From: [REDACTED]
Sent: 16 August 2023 11:17
To: Planning EConsultation <planning.econsultation@West-Norfolk.gov.uk>
Subject: FAO Mrs J Forder: Your ref: 23/1195/LB Tower Farmhouse, Station Road, Tower End, Middleton, Norfolk

Thank you for informing the Georgian Group of an application to undertake works of demolition and alteration to the above grade II listed building. The Group wishes to register its formal objection to these proposals for the following reasons.

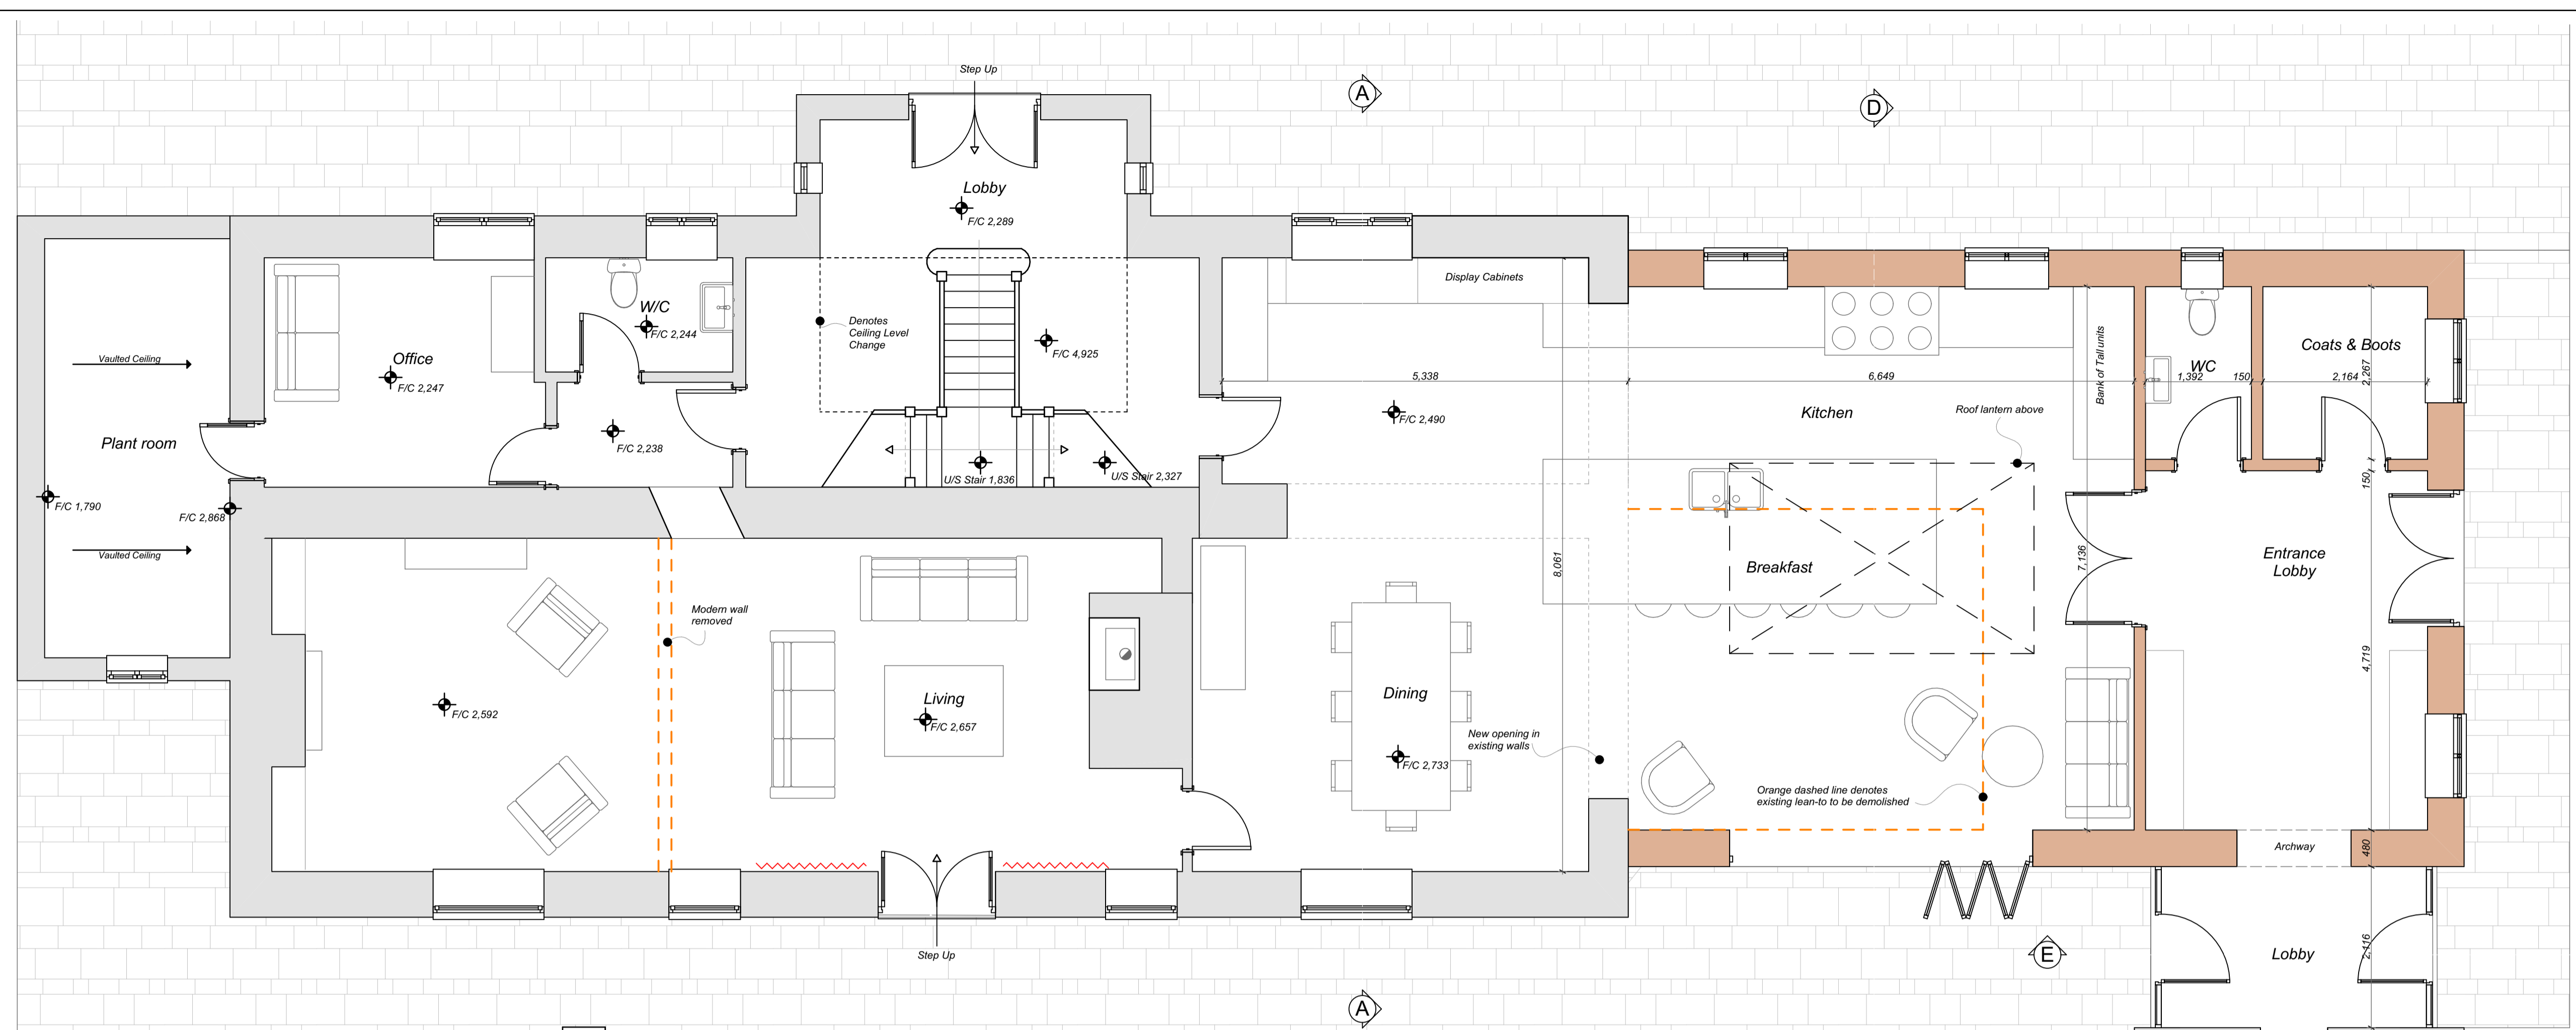
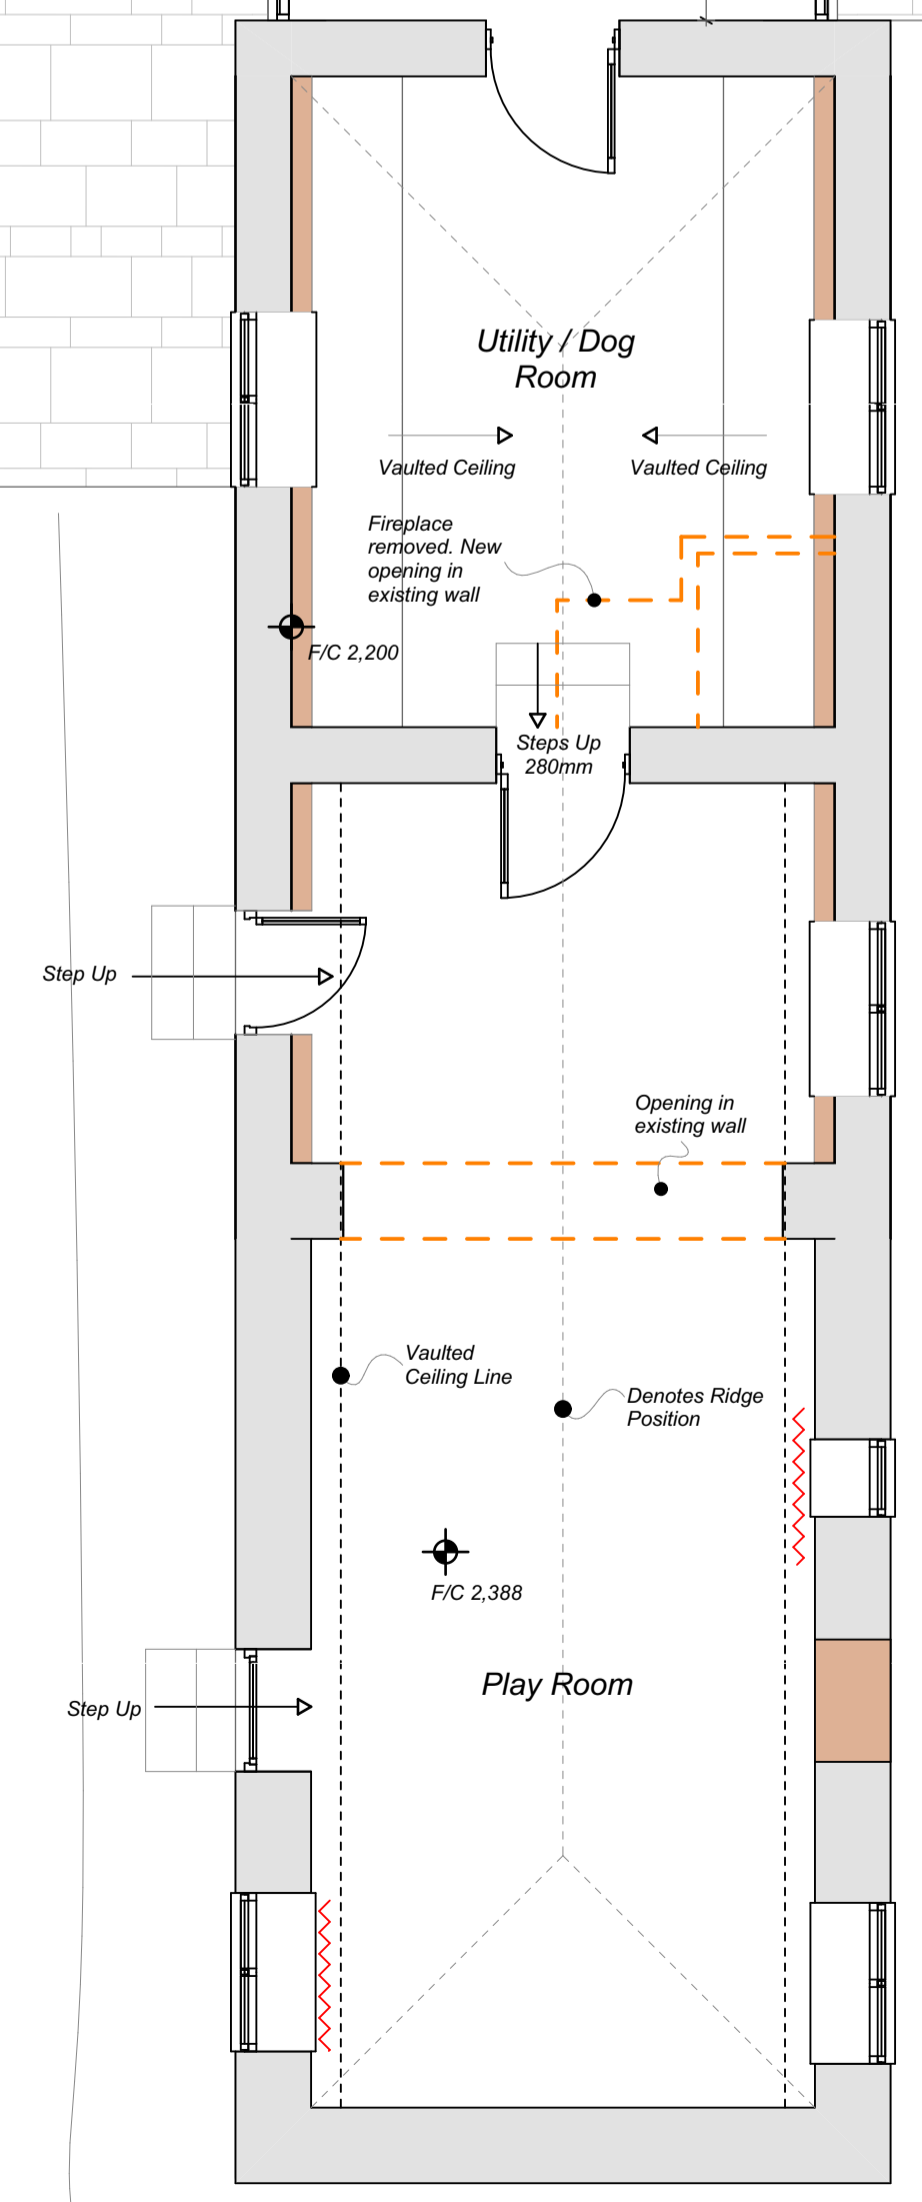
It is proposed to demolish a single storey nineteenth century wing and replace it with a much larger structure, also removing much of the original gable end wall of the farmhouse and a chimneybreast at ground floor level. Much of the remains of an historic internal partition would also be removed together with a further partition which the applicant describes as 'modern'. In their totality these proposals will cause a significant degree of harm to the historic fabric, planform, and significance of the listed building, adding to the cumulative detrimental impact of the alterations undertaken post 2015.

The Group has concerns about the size of the proposed replacement structure in relation to the existing farmhouse, and about its relationship to the adjacent outbuilding. Extending the new wing to the north will also lead to the loss of an historic window opening within the gable. The proposed roof lantern is a particularly assertive element of the proposed design which will detract from the setting of the original listed building.

Evidence should be provided that the partition within the living room which is to be removed is indeed of relatively recent date. Information should also be provided to explain the age and significance of the outbuilding to which the house is to be connected, and to explain the impact of the proposed alterations upon its significance. We also note that no information has been provided to explain the impact of the demolition of the wing and the erection of a larger new structure on the setting of the other historic buildings which form part of the former farmstead complex.
